Your Ref: OWPC19314
Our Ref: K/23/18/PL 12-06-2018
Please ask for:
Mrs A Gardner

Demolition & erection of 1 No. dwelling with swimming pool.
Little Deerswood Gorse Avenue East Preston

Thank you for your internet representation made on 16th July 2018 which has been recorded as '**an objection**' with the comments as follows:

North & East Elevations as proposed

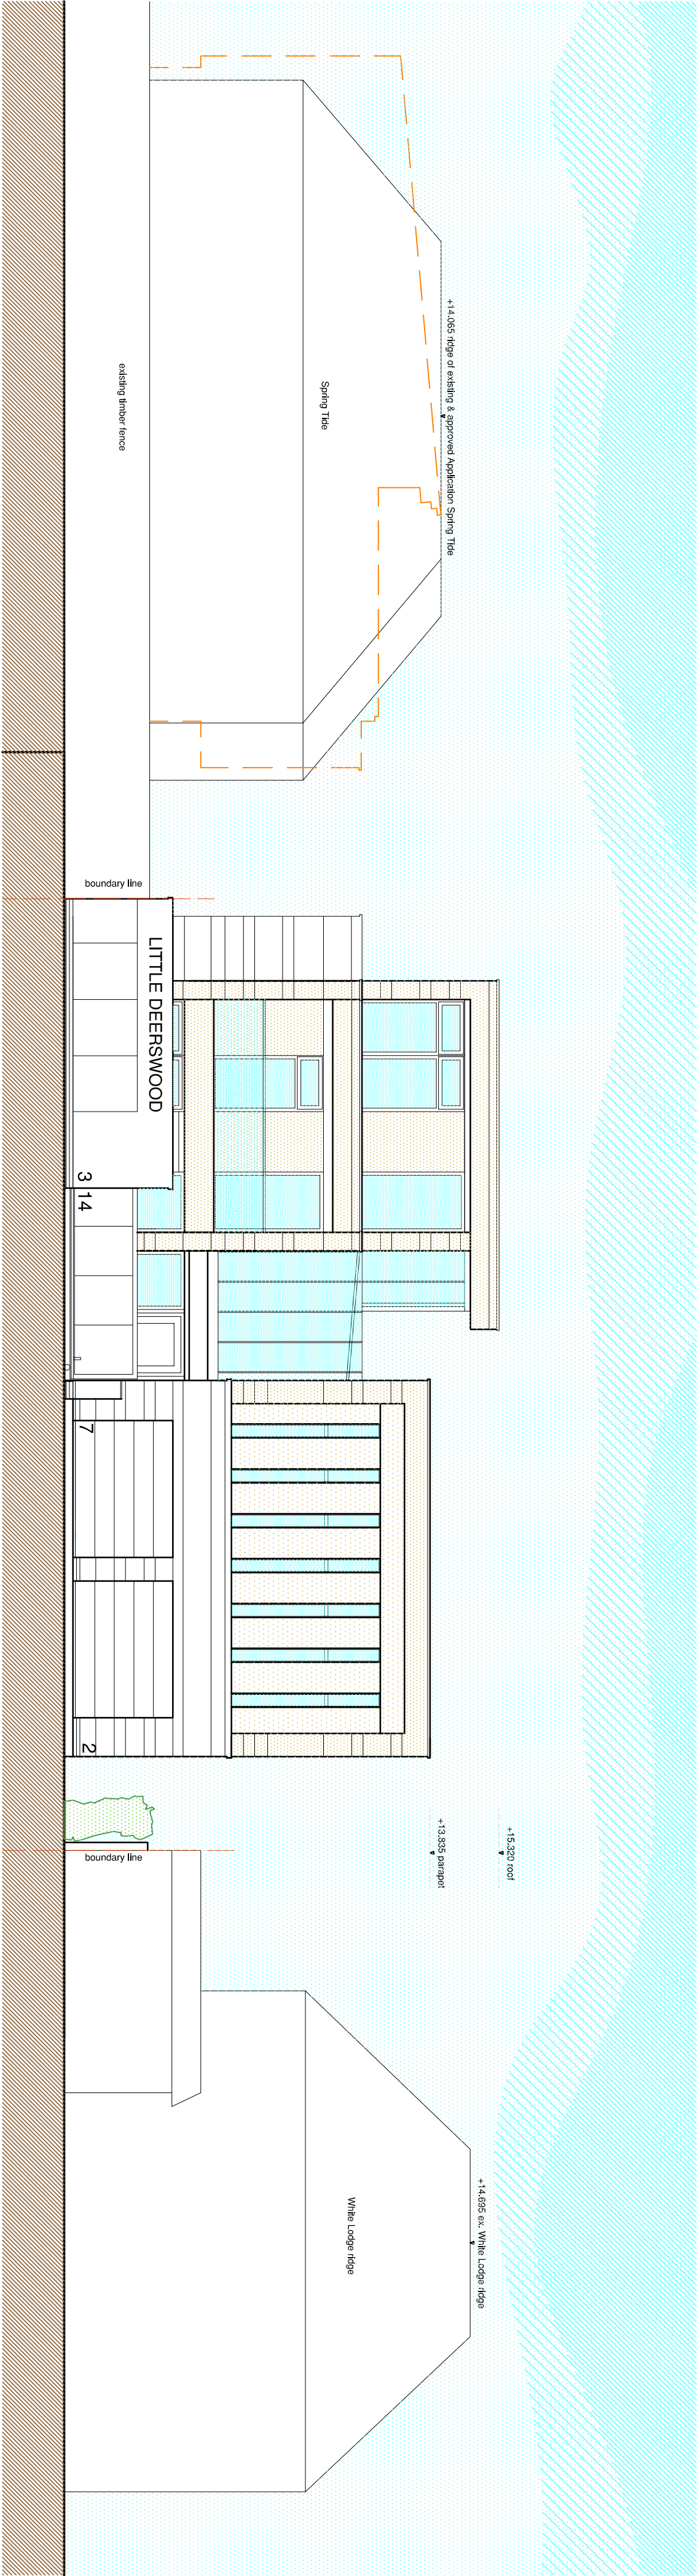
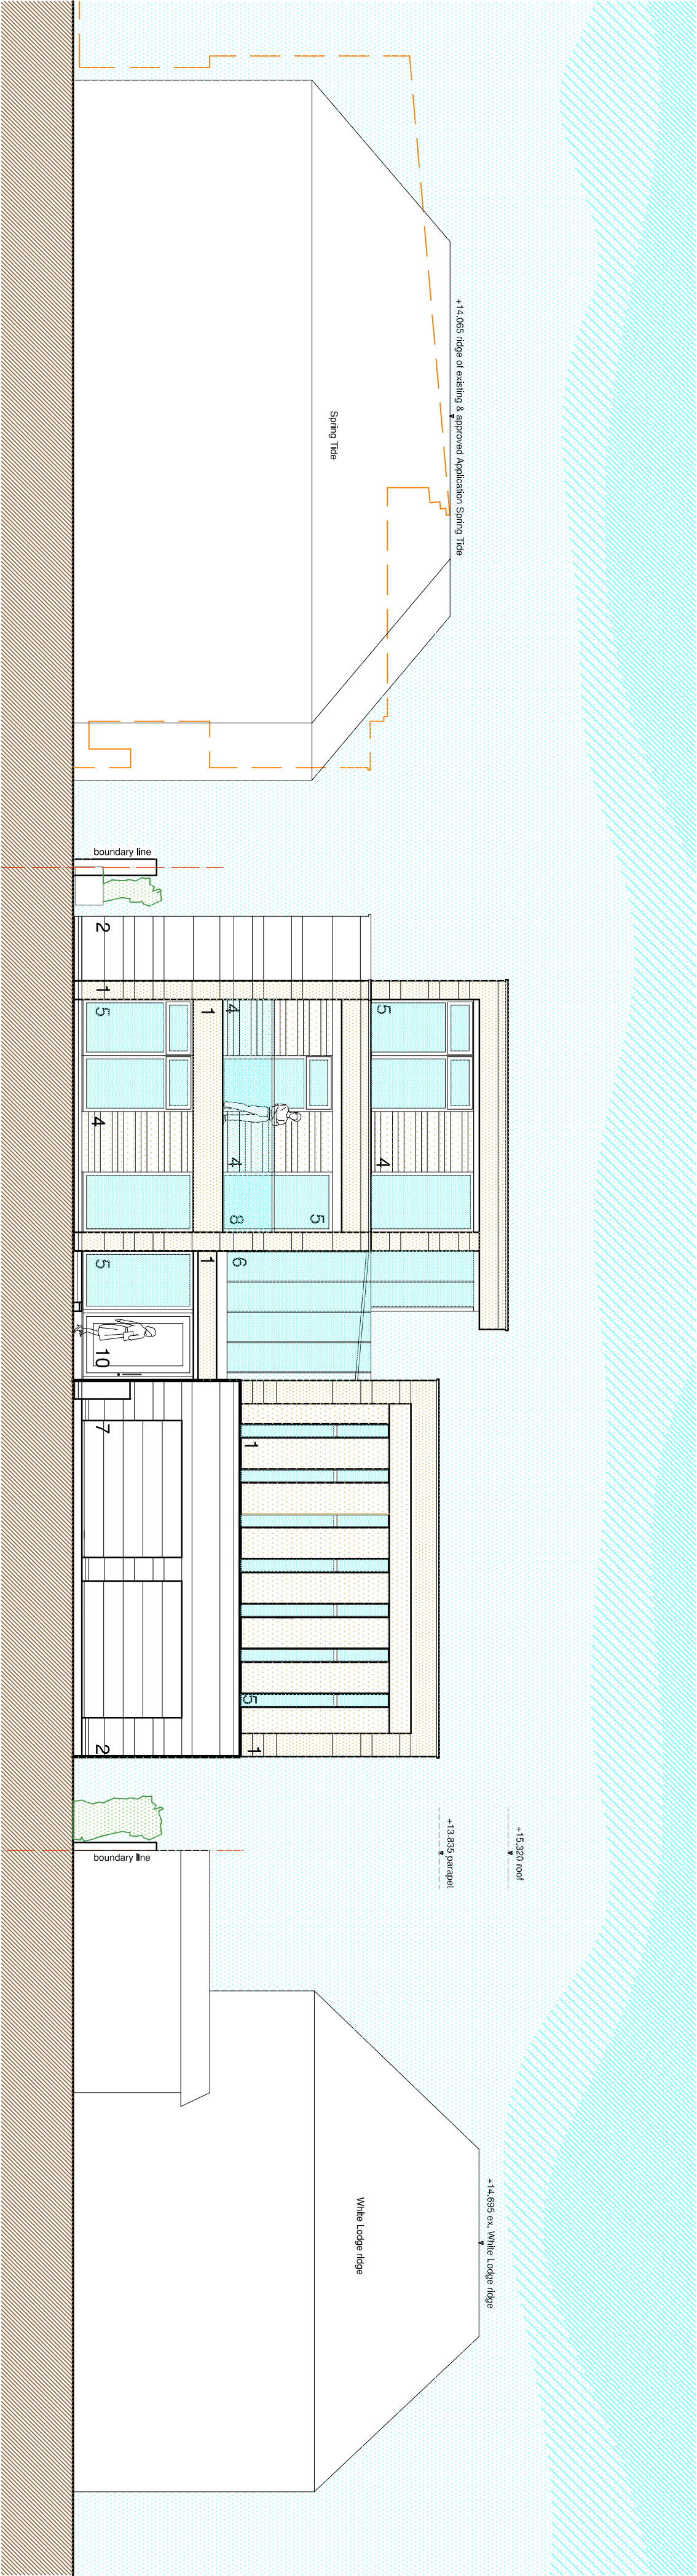
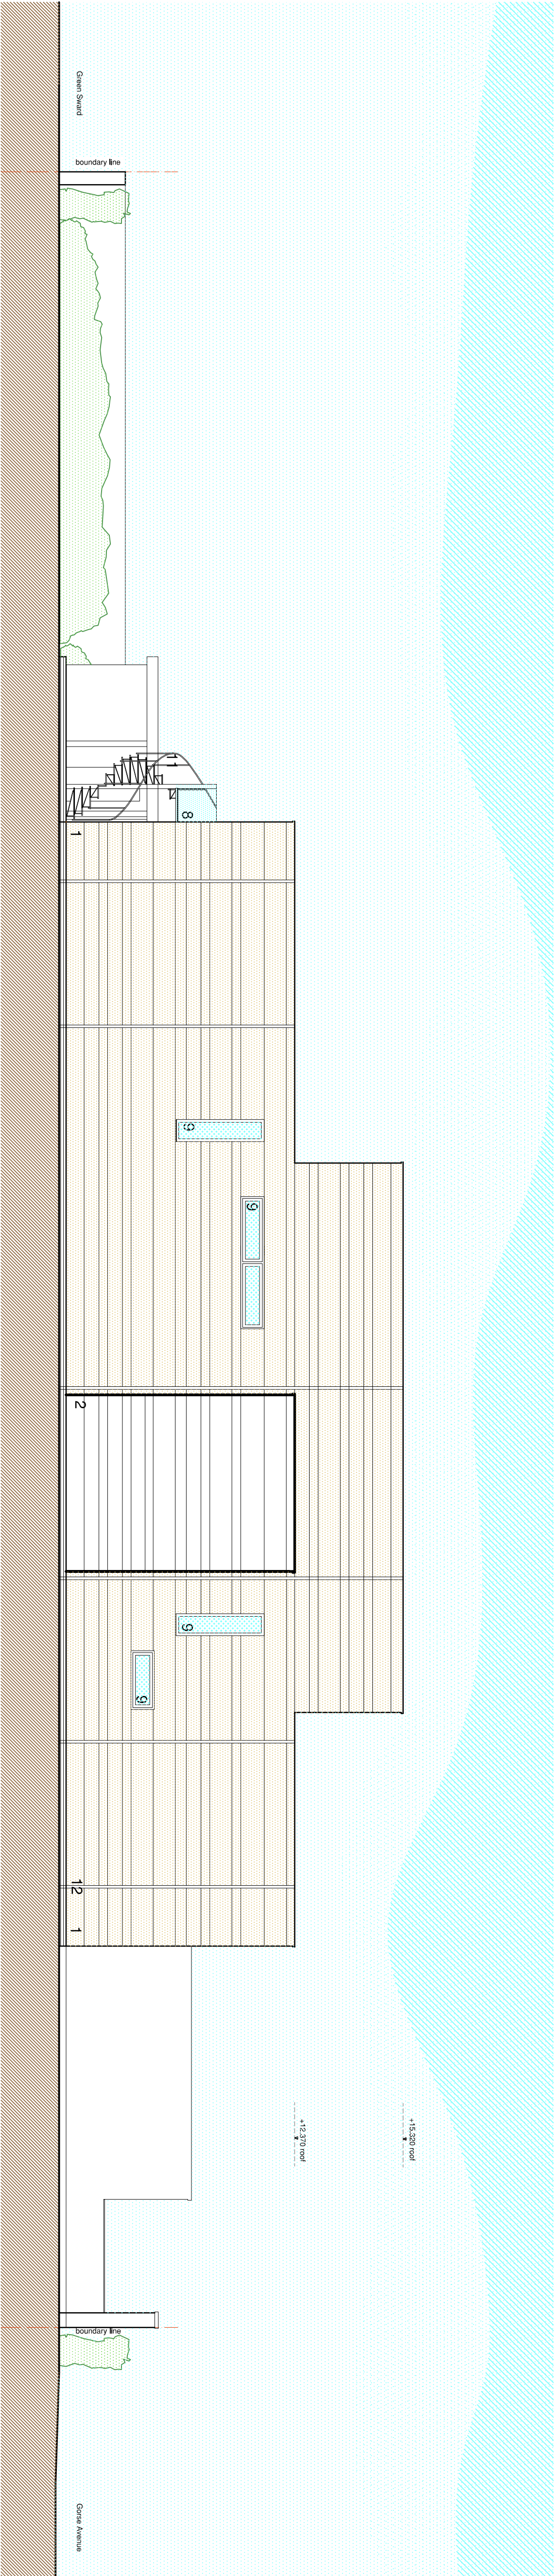
*The extension of this dwelling to the east and increasing it to 3 floors impacts my privacy significantly.
The plans submitted increase window space to the north which overlooks my property.
Contrary to point 5.3 on the planning statement, The plans do not improve visual separation between buildings, they merely create loss of gaps between dwellings and a higher building which make this an intrusive and overbearing application and results in significant loss of my families privacy.*
